From: Sue Howell <Sue.Howell@arun.gov.uk>
Sent: 03 February 2022 14:03
To: Planning.Responses <Planning.Responses@arun.gov.uk>
Cc: David Easton <David.Easton@arun.gov.uk>
Subject: Planning Consultation on: A/256/21/RES

Application ref: A/256/21/RES

Description: Approval of reserved matters following outline consent A/40/18/OUT for the erection of 525 No residential dwellings with associated parking, landscape, play areas & public open space.

Location: Land North of Water Lane Angmering

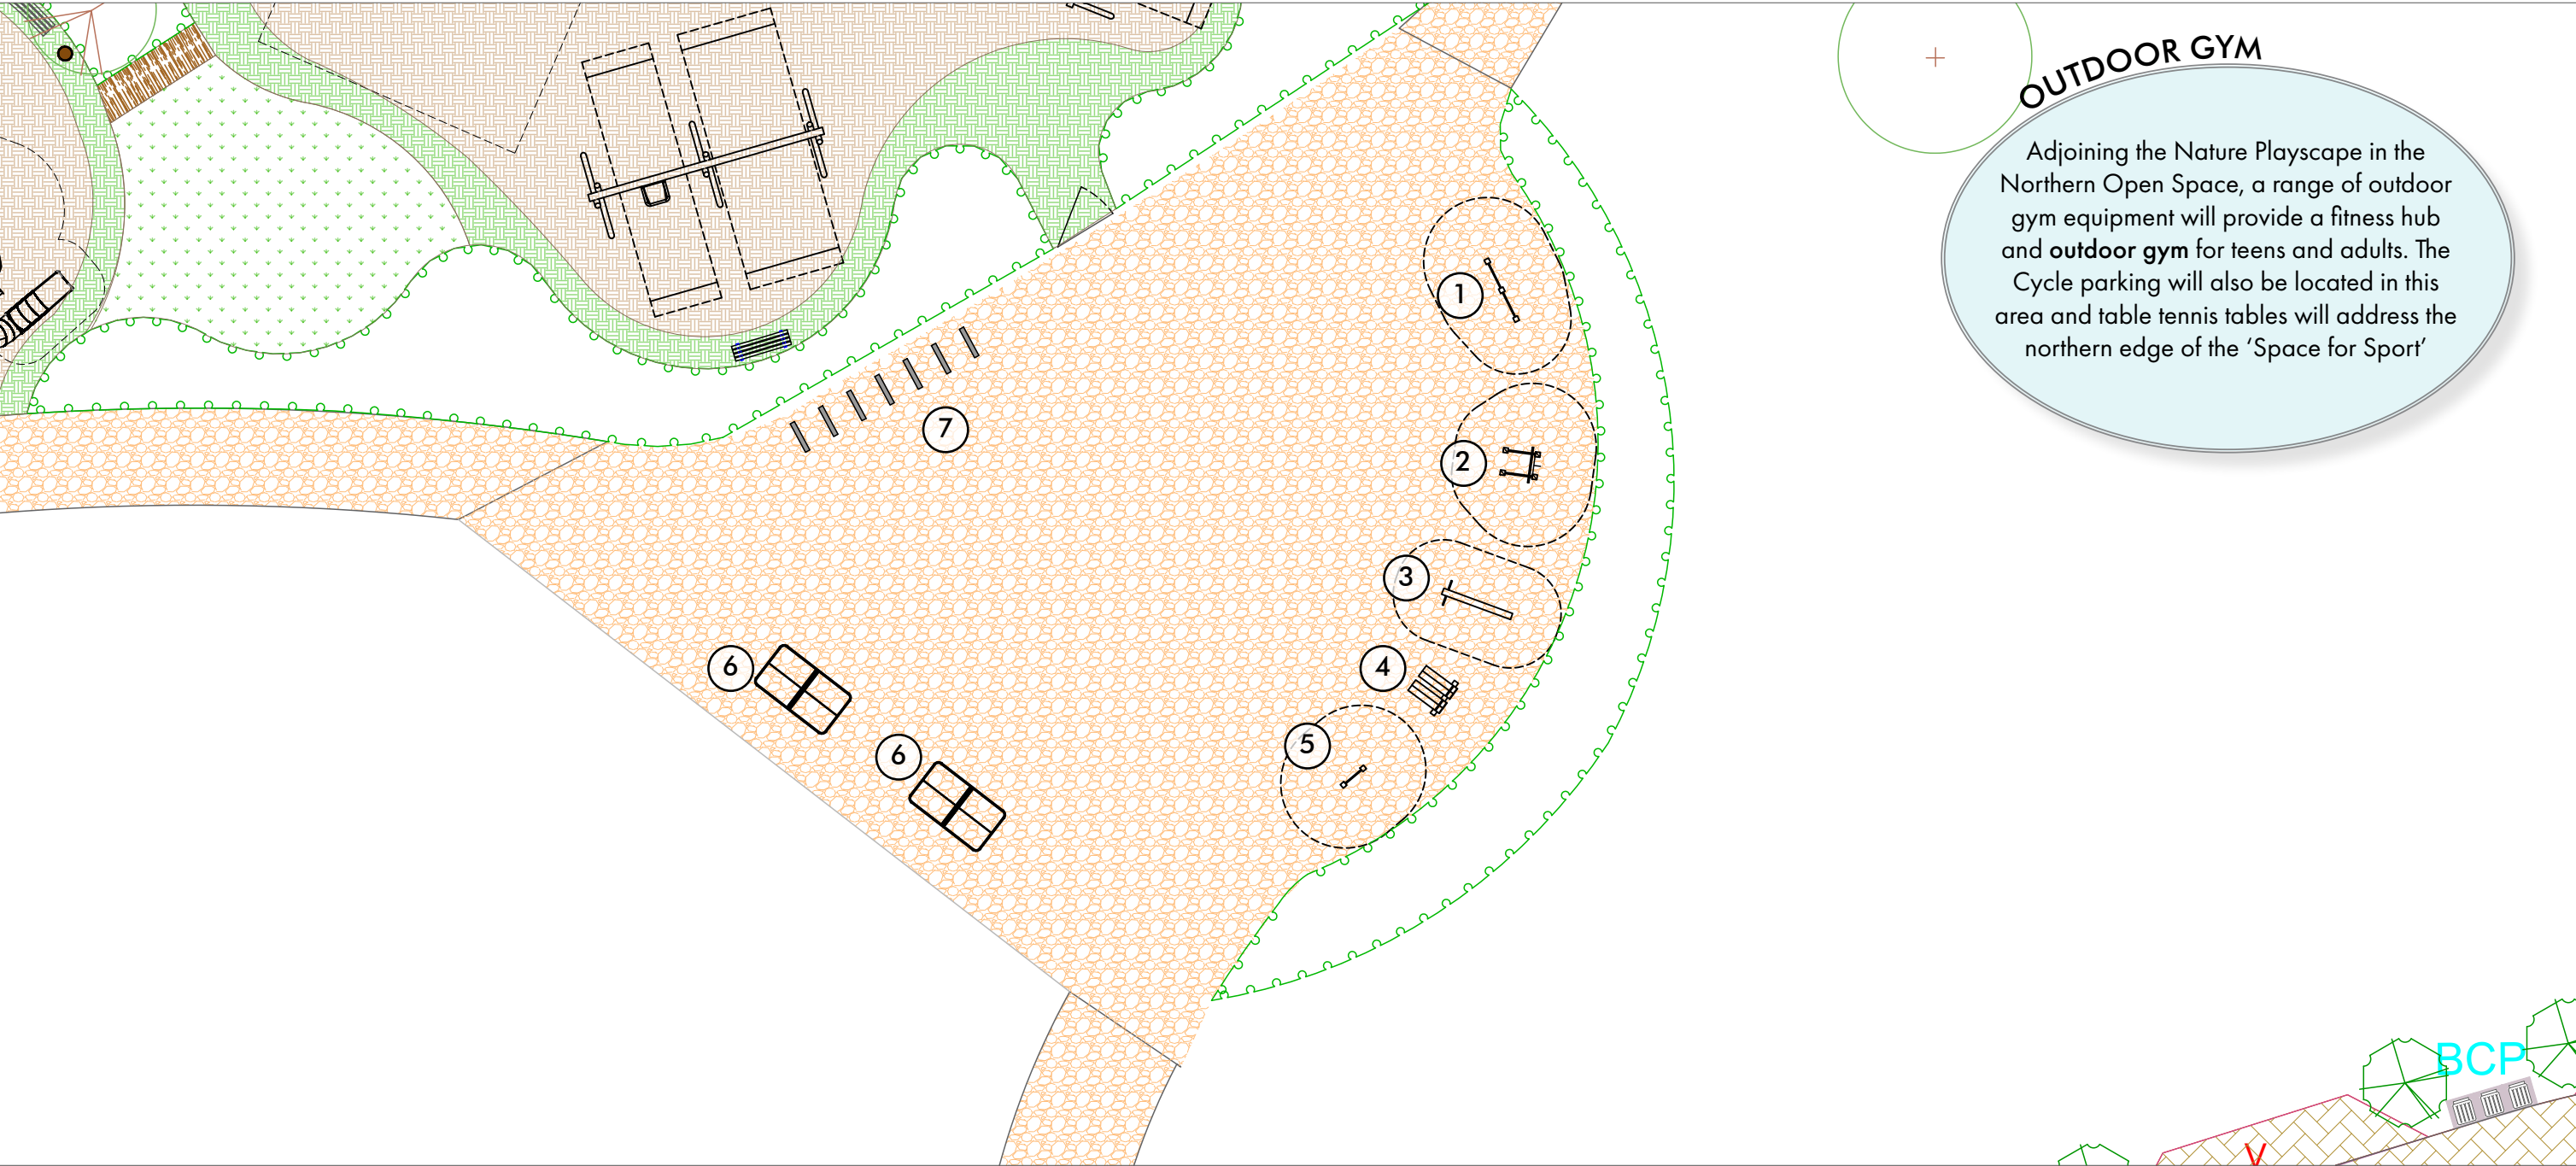
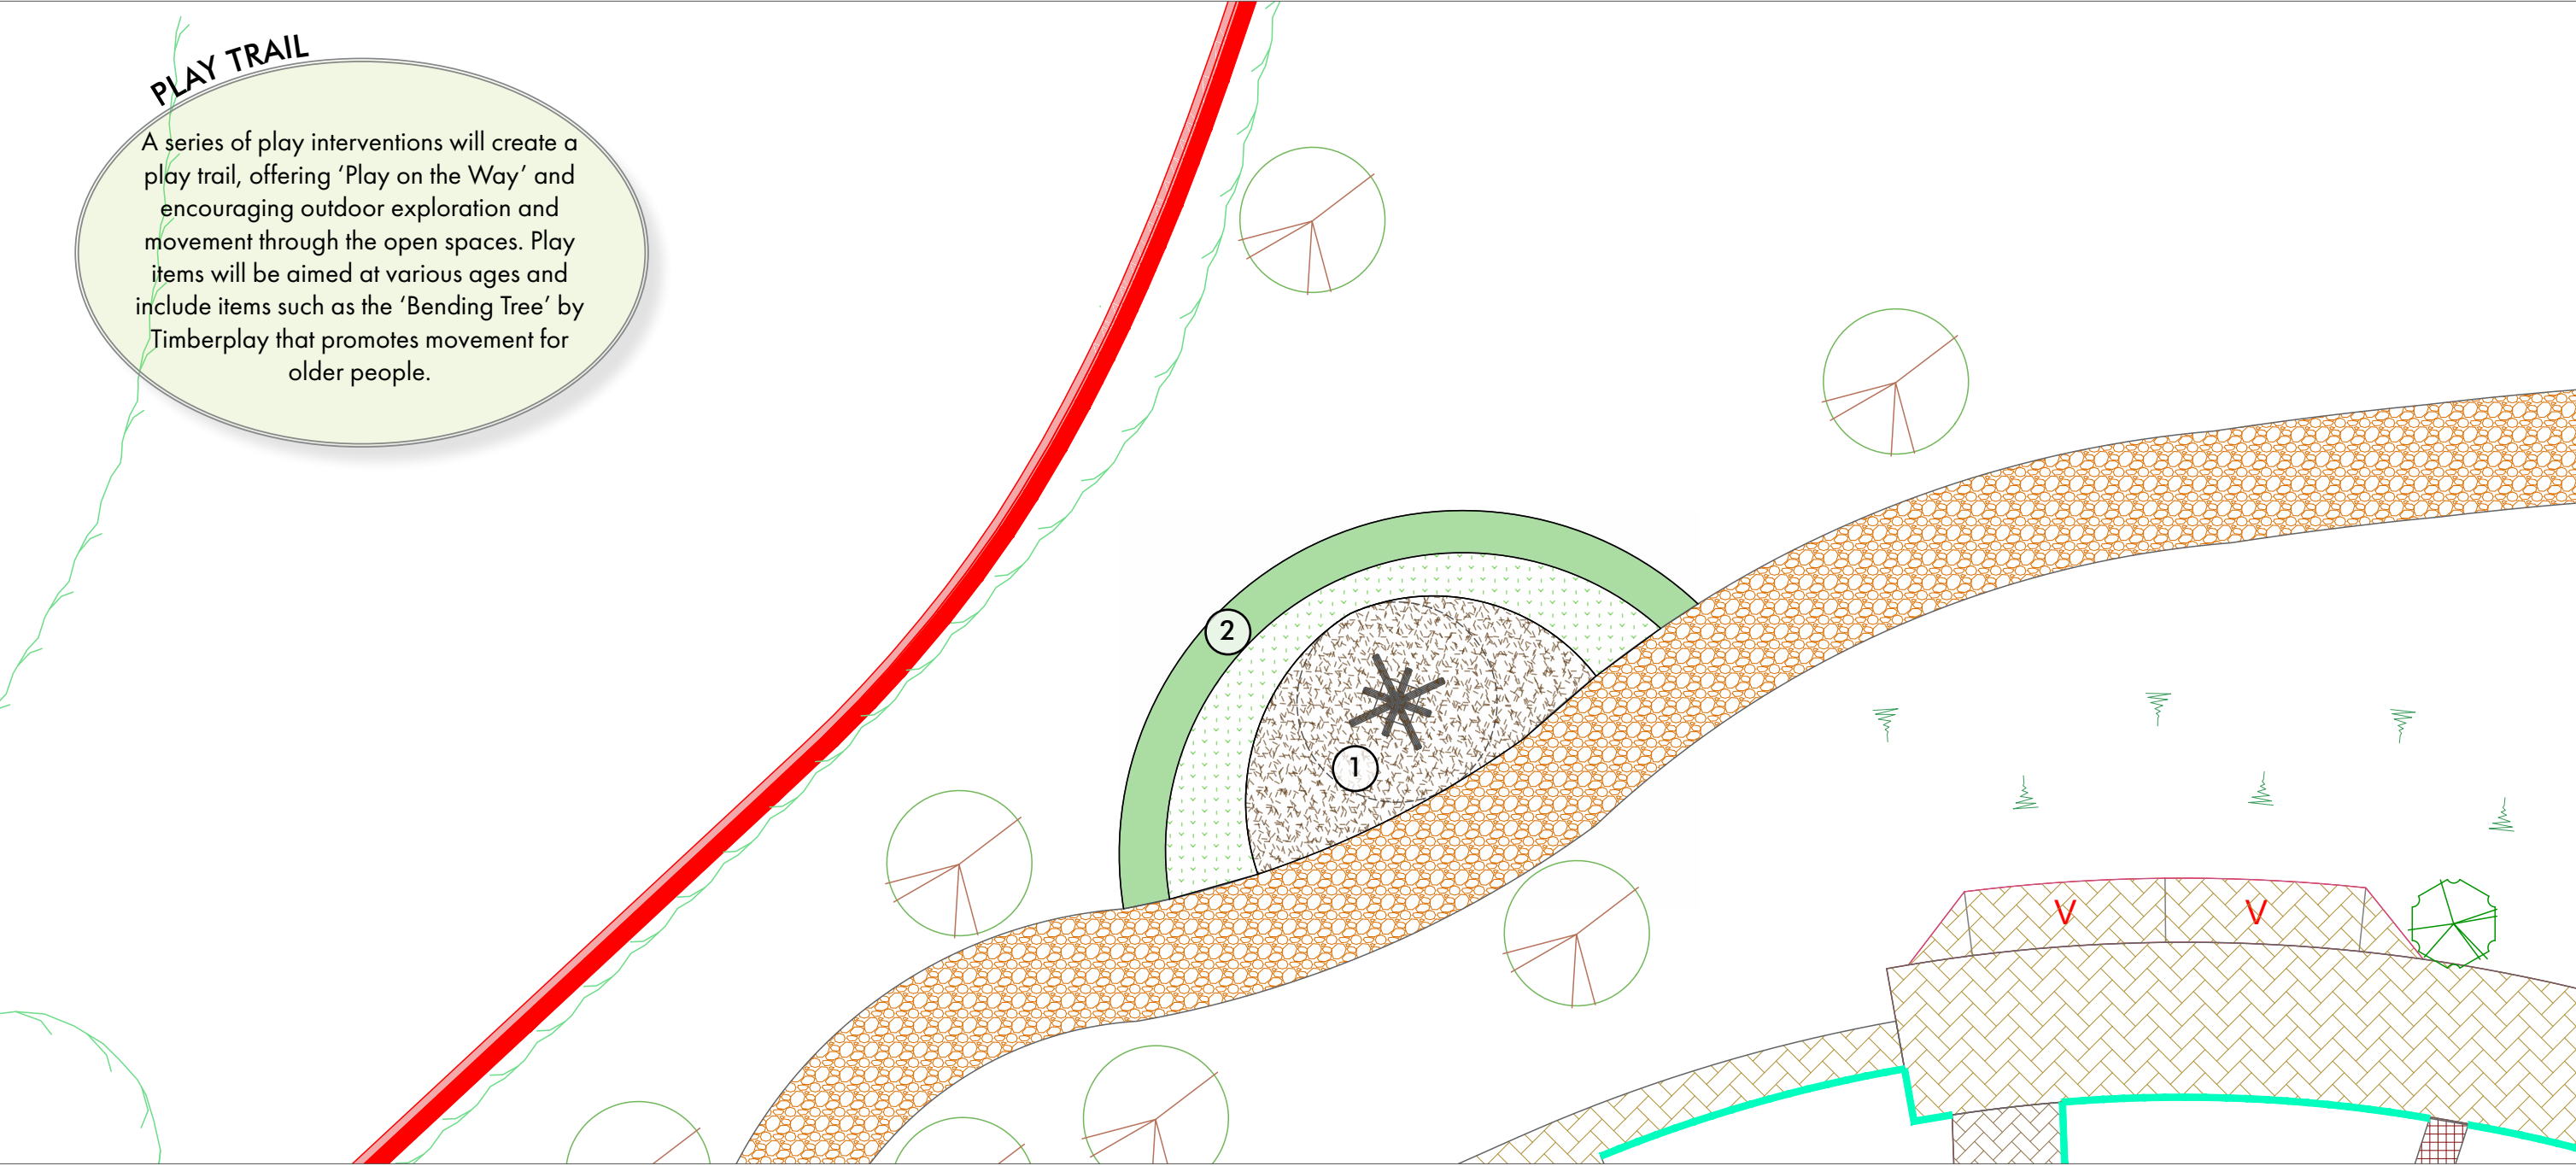
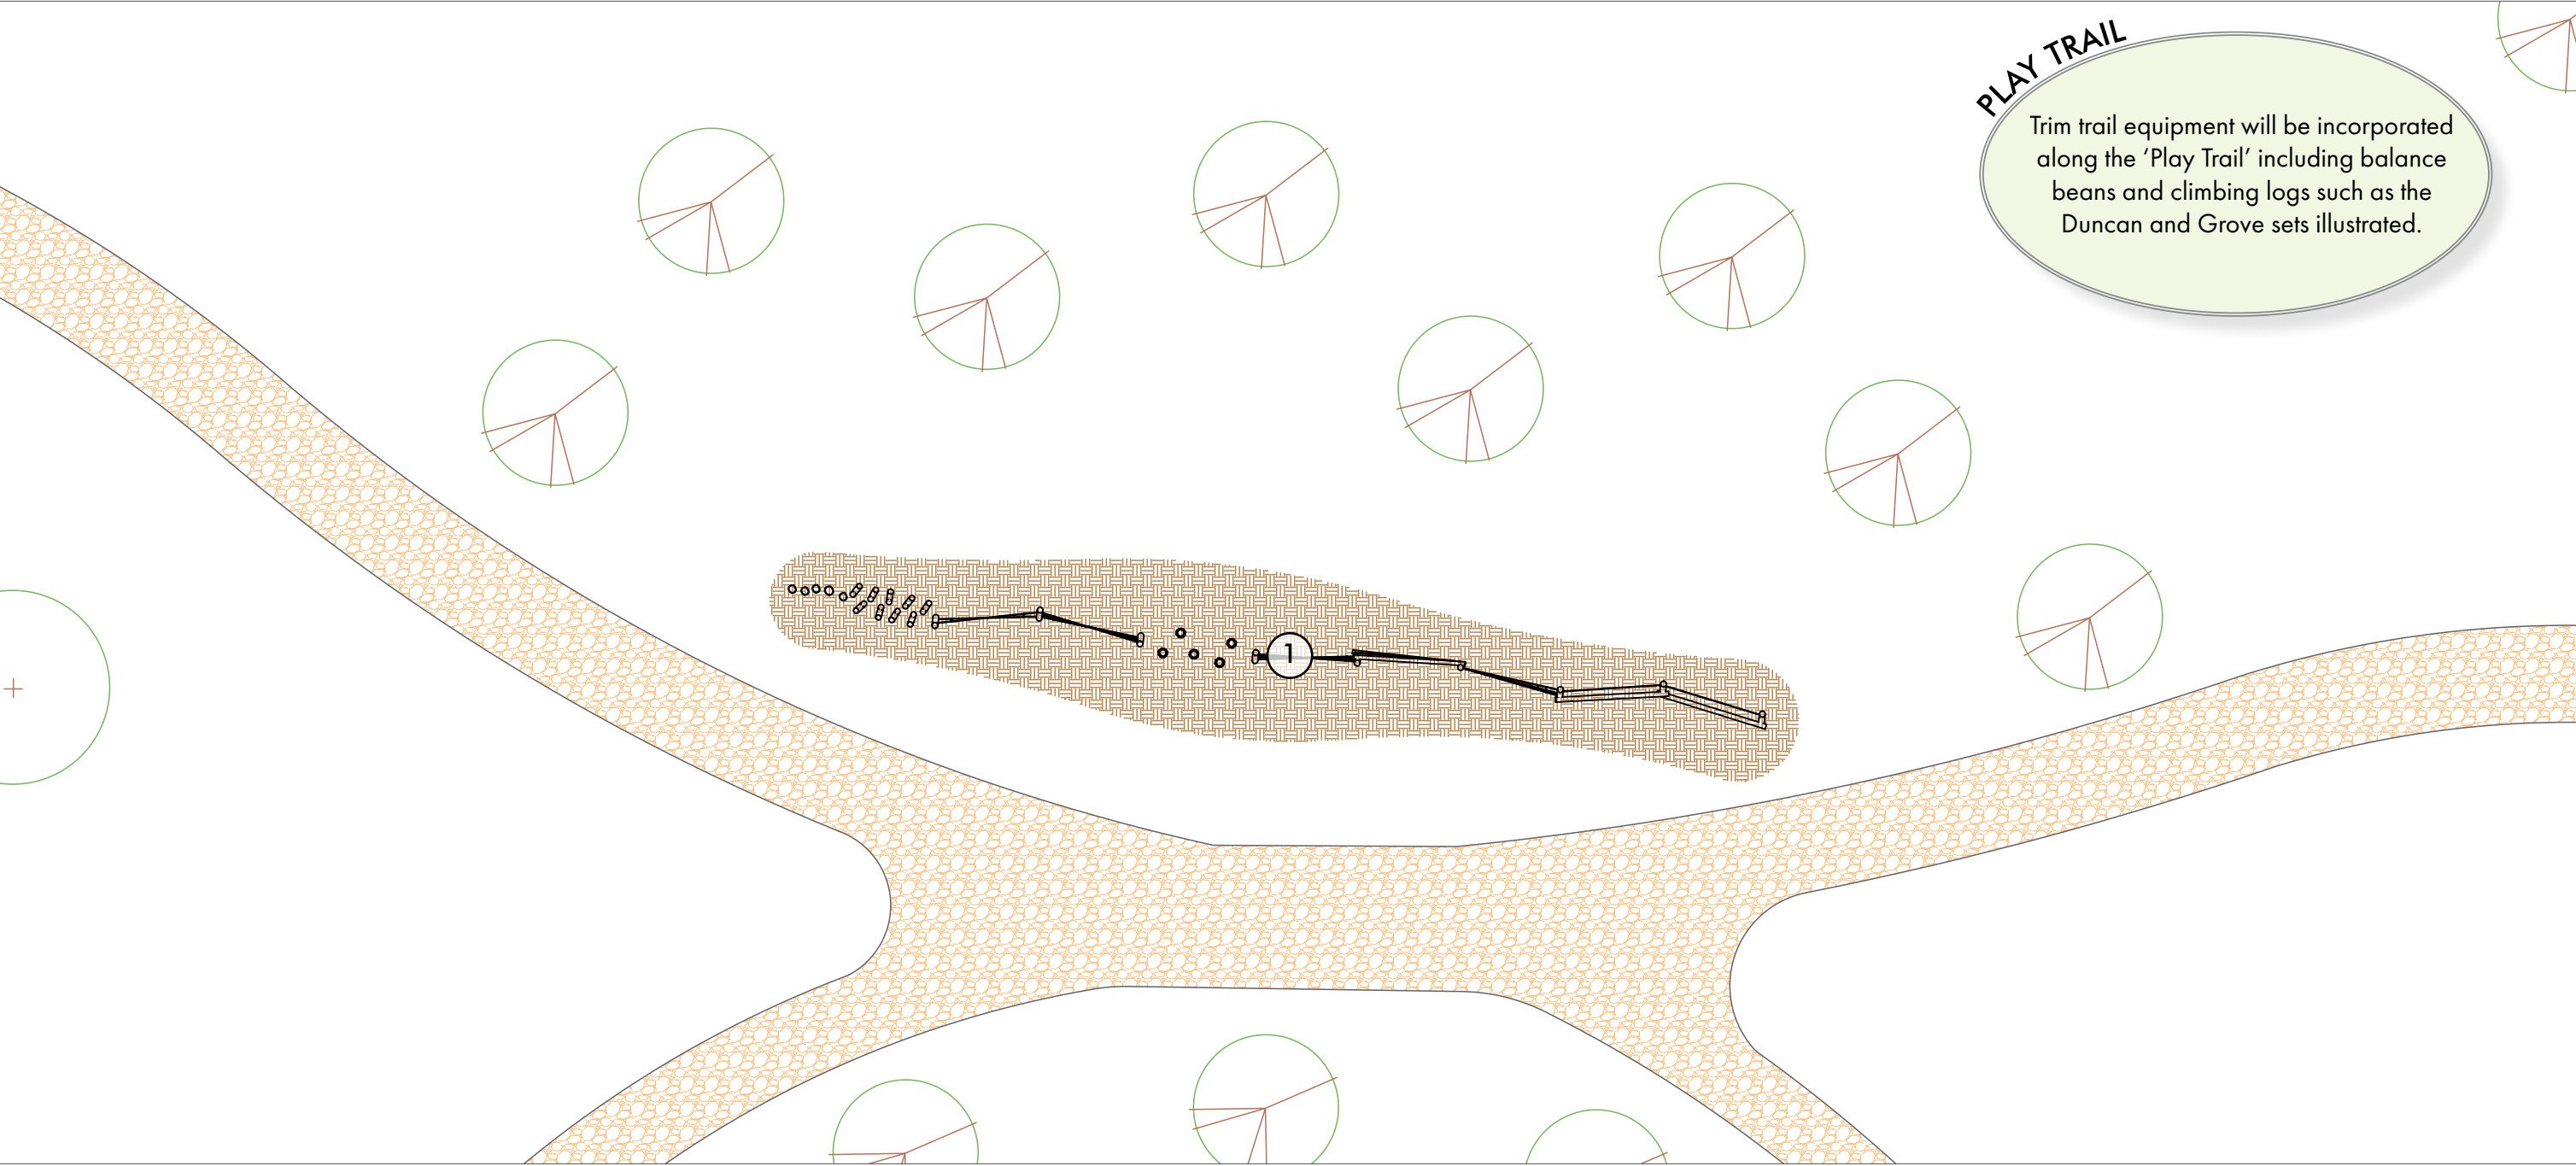
- The indicated Play including LAPs, LEAP, Sports and Fitness trail need further detail to be submitted re specification and equipment choice and accessibility of these. These need to demonstrate inclusive play, be challenging and material choice fitting for the location. Detail re general site furniture ie seating, litter bins, cycle stands etc to be submitted and approved.
